**Subject:** FW: 6/2021/0882/VAR 101 Brookmans Avenue Brookmans Park Hatfield AL9 7QG  
Variation of condition 10 (drawing numbers) on planning permission  
6/2019/2313/FULL

**From:** Anita Parry [mailto:Anita.Parry@hertfordshire.gov.uk] **On Behalf Of** Ecology  
**Sent:** 03 June 2021 17:55  
**To:** David Elmore <d.elmore@welhat.gov.uk>  
**Subject:** FW: 6/2021/0882/VAR 101 Brookmans Avenue Brookmans Park Hatfield AL9 7QG Variation of condition 10 (drawing numbers) on planning permission 6/2019/2313/FULL

Drawing Title  
 PROPOSED SITE PLAN  
 PROPOSED GATES

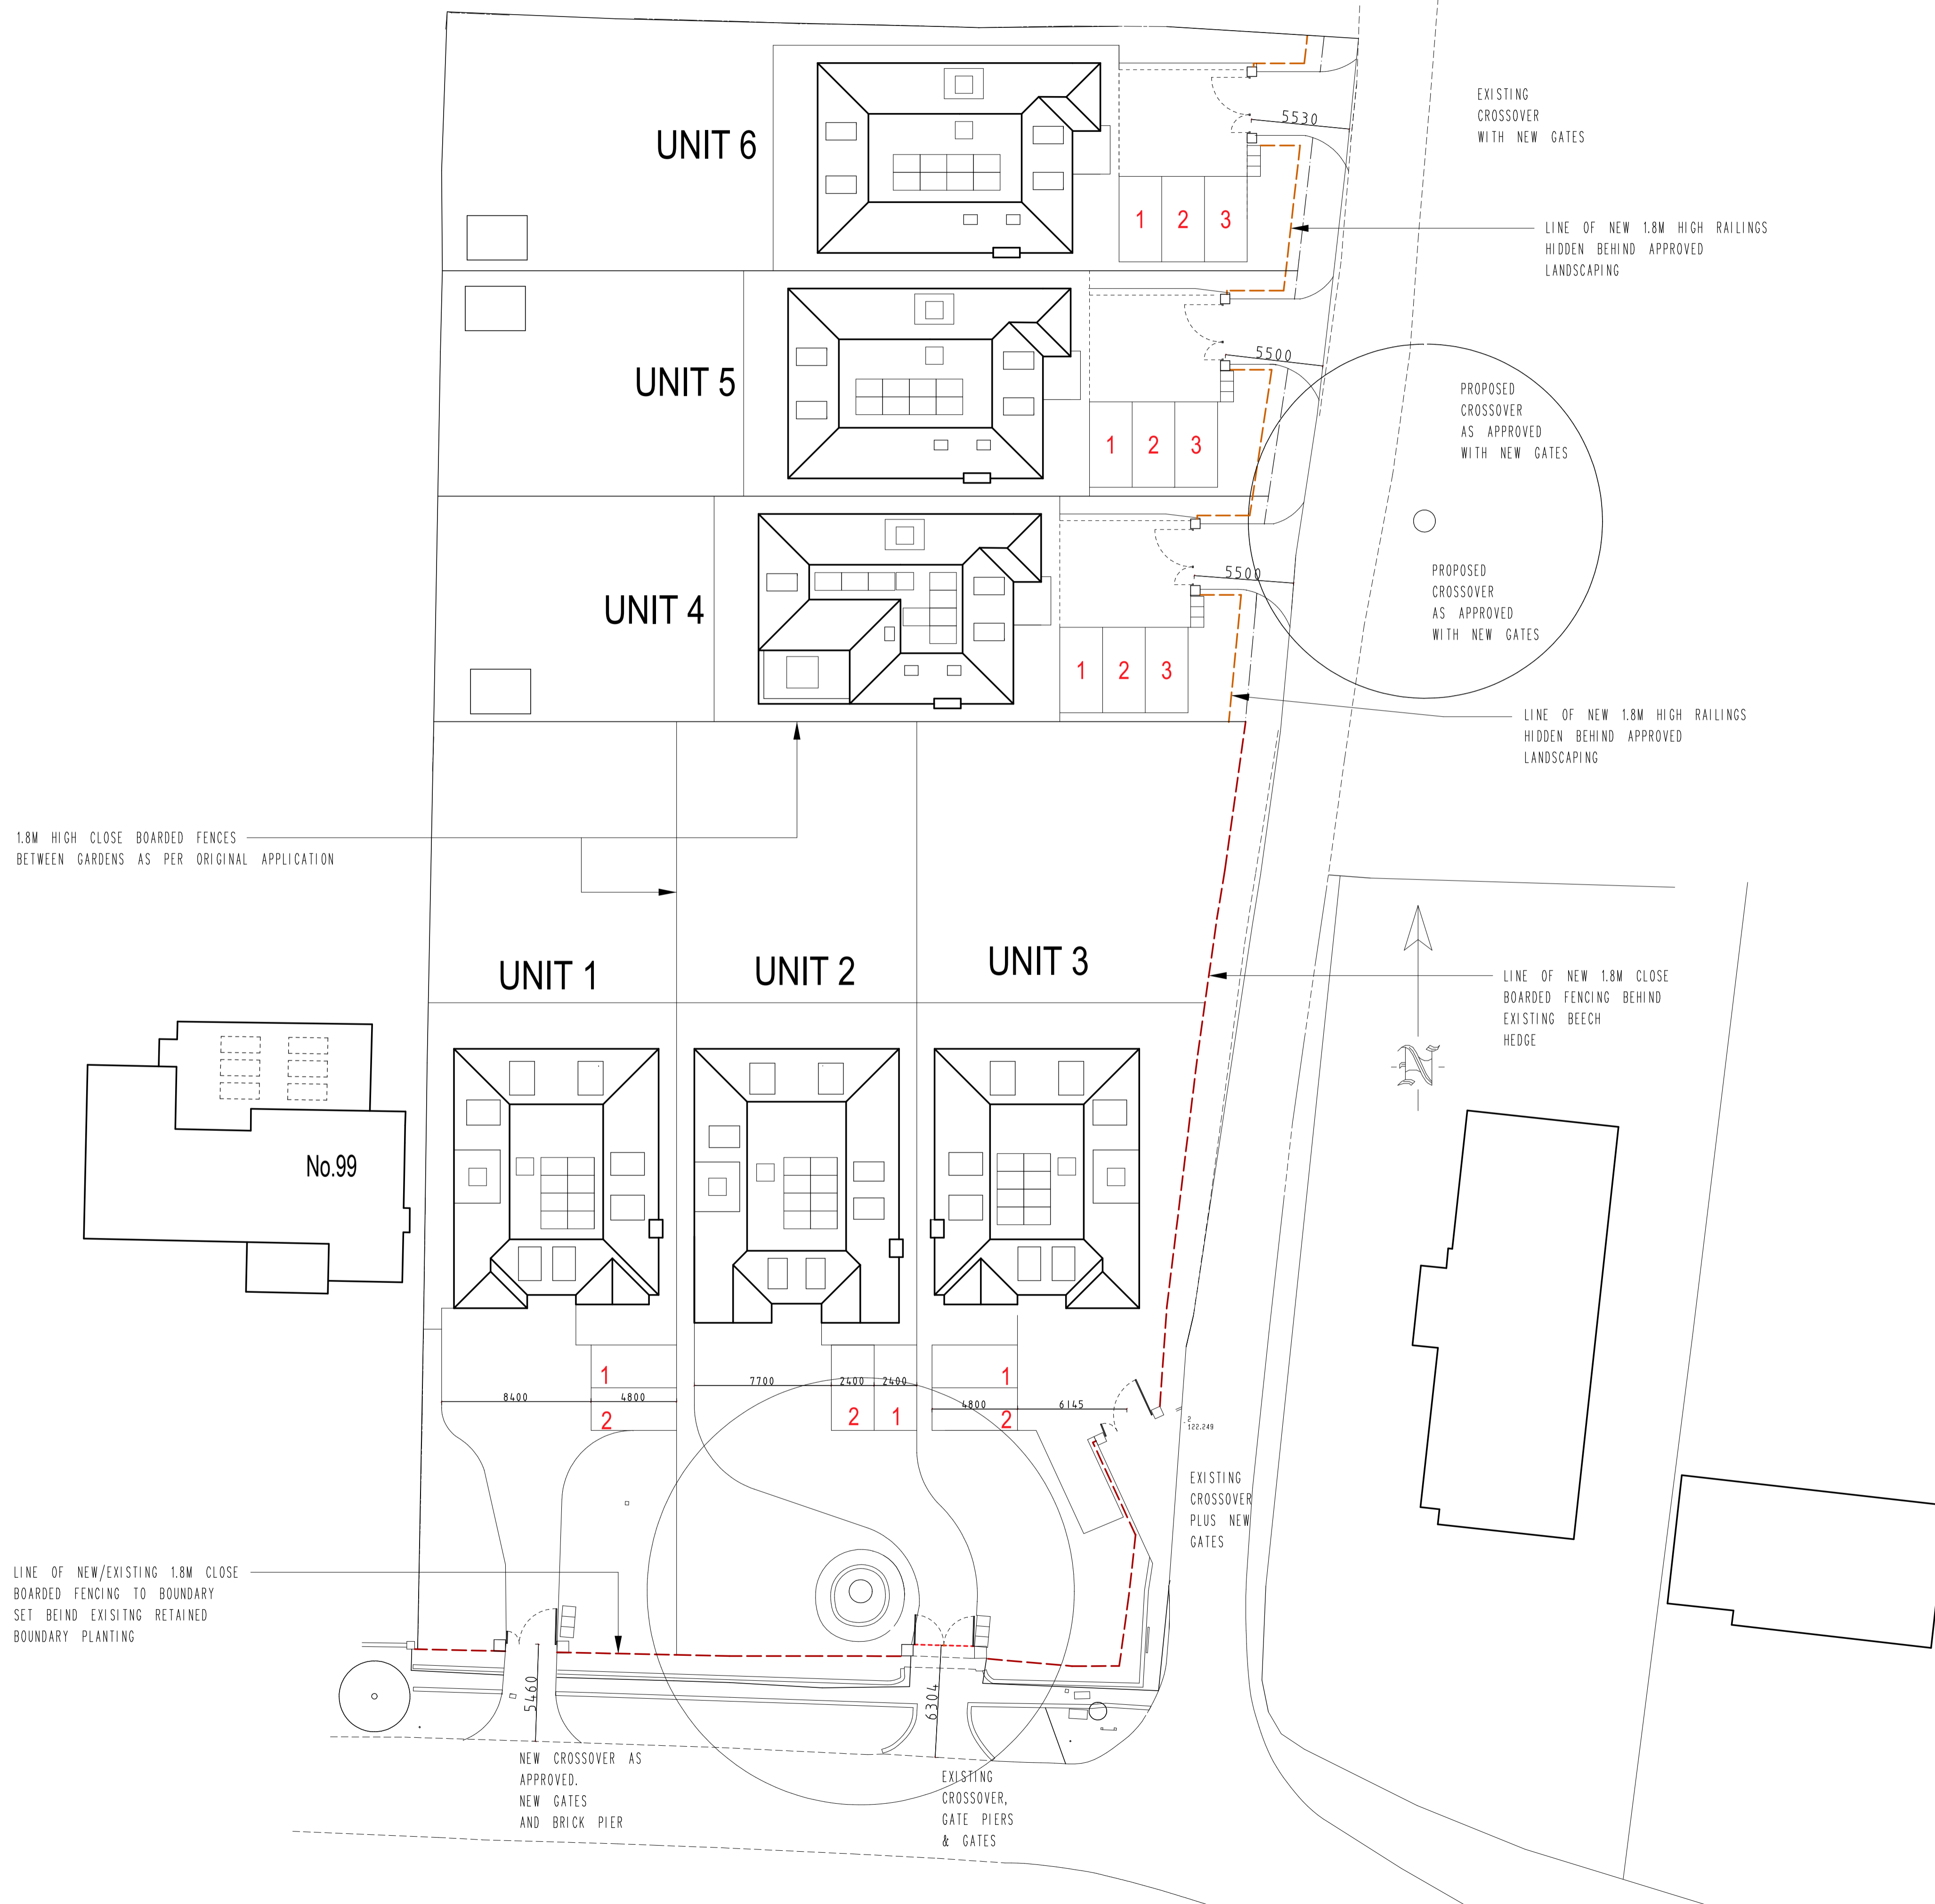
Any substantial removal of beech hedgerow or other native trees/bushes for these gates should be compensated for with new native species planting elsewhere in the development scheme, in an appropriate location within the site or to infill any gaps in the boundary.
